Subject: Advice on EIS – Crescent Parklands – SSD-70283710

CPHR advice on the EIS for Crescent Parklands – SSD-70283710

Figure 12: Arboricultural Impact Assessment, page 1

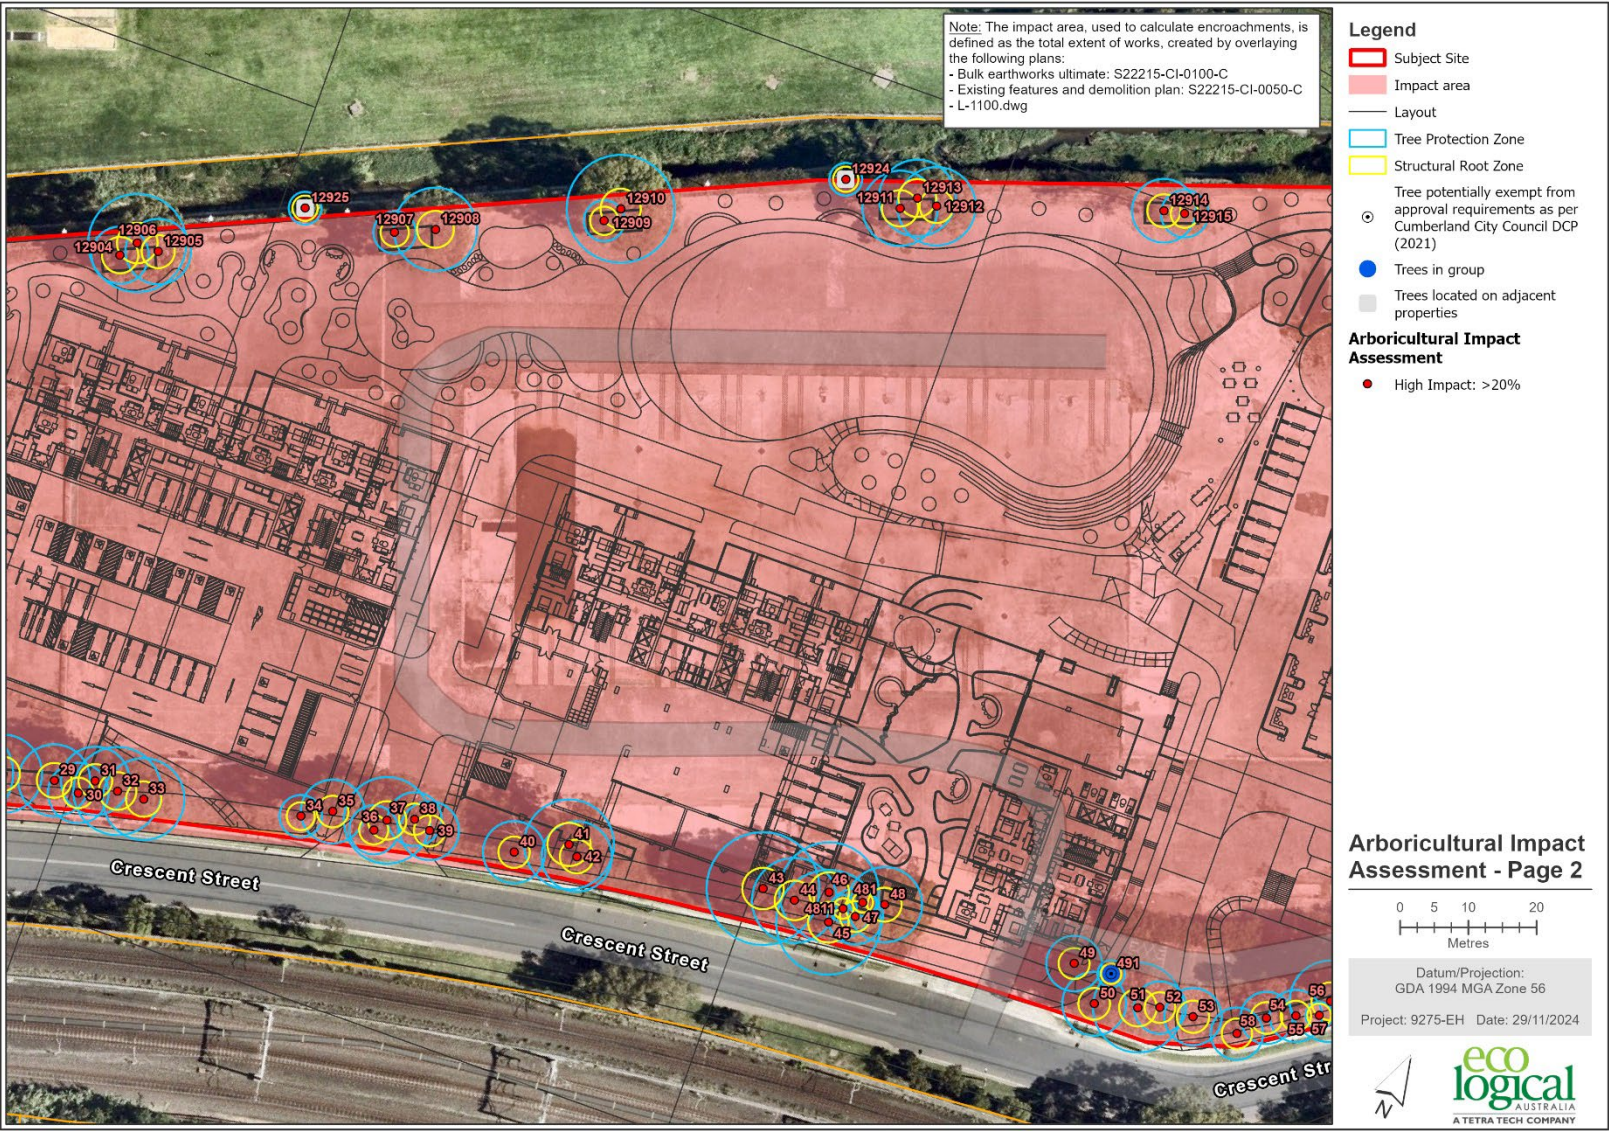
5.	Arboricultural Impact Assessment	<p>Based on a review of the AIA, CPHR have identified the following issues:</p> <ul style="list-style-type: none"> • The AIA states that the entire site is 'impacted' (Figure 12 and Figure 14), and that due to this, no trees can be retained on site. CPHR does not support this justification. • CPHR notes that most trees are located along the site boundary, in locations where landscaping/open space is proposed. There is opportunity for impacts to tree protection zones (TPZ) to be appropriately avoided / minimised. For example, impacts could be appropriately avoided / minimised by measures including but not limited to: <ul style="list-style-type: none"> ○ retaining trees by adjusting plans to limit/reduce grade level changes ○ specifying suitable fill material for example coarse-textured soils, for shallow fill areas ○ relocating structures away from TPZs, employing hand excavation ○ carefully removing existing hardstand under the supervision of an arborist ○ and/or implementing tree-sensitive construction methods. • The threshold specified in the AIA (page 14-15 of a >20% TPZ encroachment automatically resulting in a tree not being viable for tree retention is not supported. Such a strict threshold is not in line with the Australian Standard (AS 4970-2009) and industry practice. • Section 3.2 of the AIA specifies that two trees are subject to 'medium' impact to their TPZs, without specifying the type of impact. The AIA further states that mitigation measures are to be implemented to retain these trees however no tree specific mitigation measures are provided in the report. • The AIA states that 'confirmation on the viability for retention must be confirmed by the project arborist prior to construction.' This approach is not supported by CPHR. The viable retention of trees should be demonstrated now, not after development consent is obtained. The viable retention of trees must be demonstrated in line with section 3.3.4 of AS 4970-2009 which may require root mapping. • Section 3.5 of the AIA specifies that four neighbouring trees will be impacted and require removal. CPHR flags that approval for the project should not be provided unless these trees can be viably retained (with an updated AIA to demonstrate this), or if this is not feasible, written confirmation should be provided by the tree owner(s) that they consent to the tree removal.

<p>Recommended action:</p> <ul style="list-style-type: none"> • CPHR recommends that the proposal is refined in consultation with a suitably qualified AQF Level 5 arborist to design, avoid and minimise impacts within the TPZs of trees that have a medium and high retention value and trees descriptive of CPW to viably retain as many trees as possible. Once this is undertaken, the plans should be updated accordingly for example landscape plan, architectural plans and bulk earthwork plan. An updated AIA and tree protection plan (TPP) is to be provided. • The updated AIA should: <ul style="list-style-type: none"> ○ List all documentation referenced during the assessment process. ○ Contain a schedule documenting: botanical and common name, age class, dimensions inclusive of, height, canopy spread, trunk diameter at breast height (DBH), calculated TPZ, calculated Structural Root Zone (SRZ), calculated development incursion into the TPZ (if any), health, structure and condition of the trees. ○ Review the tree retention values provided in the current AIA of trees with a diameter (DBH) of 50 cm or greater to ensure the appropriate retention value is assigned in line with Appendix A of the AIA. ○ Assess the proposed development in its entirety. This includes, but is not limited to, proposed stormwater infrastructure, retaining walls, grade changes, excavation and removal of hardstand. ○ Identify the specific type of impact within each TPZ of trees identified to have a medium or high tree retention value and trees descriptive of CPW. ○ Ensure impacts to TPZs are avoided/minimised to support the viable retention of trees wherever possible. ○ Demonstrate that retained trees can be retained viably in accordance with the Australian Standard 4970 – 2009. ○ Include specific mitigation measures to be implemented throughout the demolition and construction phase for each tree to be retained. These specifications must be tree and site specific, not generic. • The updated TPP should: <ul style="list-style-type: none"> ○ Be at a scale of 1:100 or 1:200 and show the location of all trees that have a TPZ extending into the development impact area. ○ Show all proposed development works, including the location of above and below ground structures and services. ○ Identify the tree protection area for each tree and clearly identify the percentage of development encroachment into the TPZ and canopy. ○ Include survey details and show the existing ground levels at the base of each tree, the DBH of each tree and the corresponding tree number. ○ Plot all tree locations with survey accuracy (by registered surveyor).

Figure 11. Targeted survey effort for species credit species within and surrounding the Subject Land.

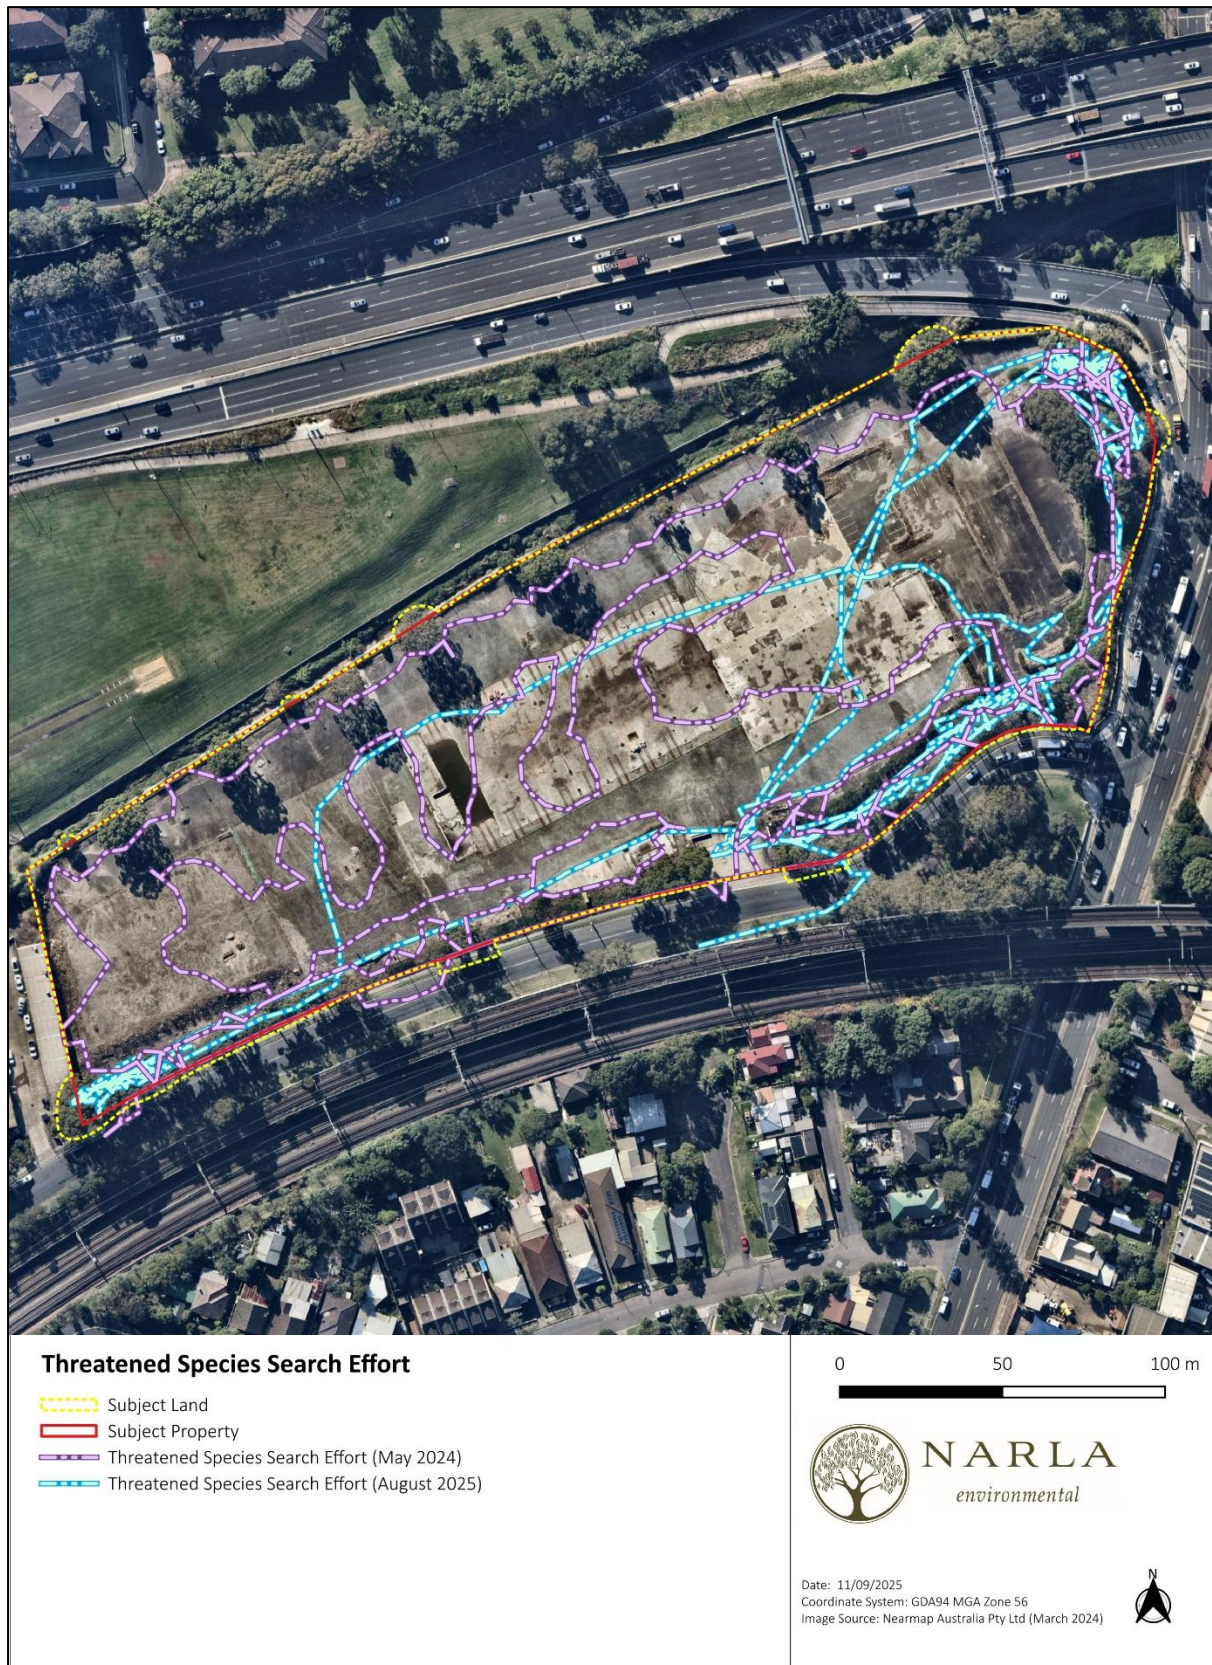
<i>Extent and Timing</i>	Pre-determination
3.	Flora and fauna surveys	<p>Section 4.3 of the BDAR states, ‘Targeted surveys were undertaken for any SAIL species credit species considered likely to have suitable habitat within the Subject Land (Figure 11). These surveys were implemented in accordance with Section 5.3 of the BAM and all relevant DCCEEW threatened species survey guidelines’.</p> <p>However, no details of the survey methods are outlined in the BDAR. Table 13 and Table 14 of the BDAR state that no targeted surveys were undertaken for any of the candidate fauna or flora species.</p> <p>Recommended action:</p> <ul style="list-style-type: none"> • The BDAR should be updated to include details of surveys undertaken in Section 4, including the ‘relevant DCCEEW threatened species survey guidelines’ used.
	<i>Extent and Timing</i>	Pre-determination
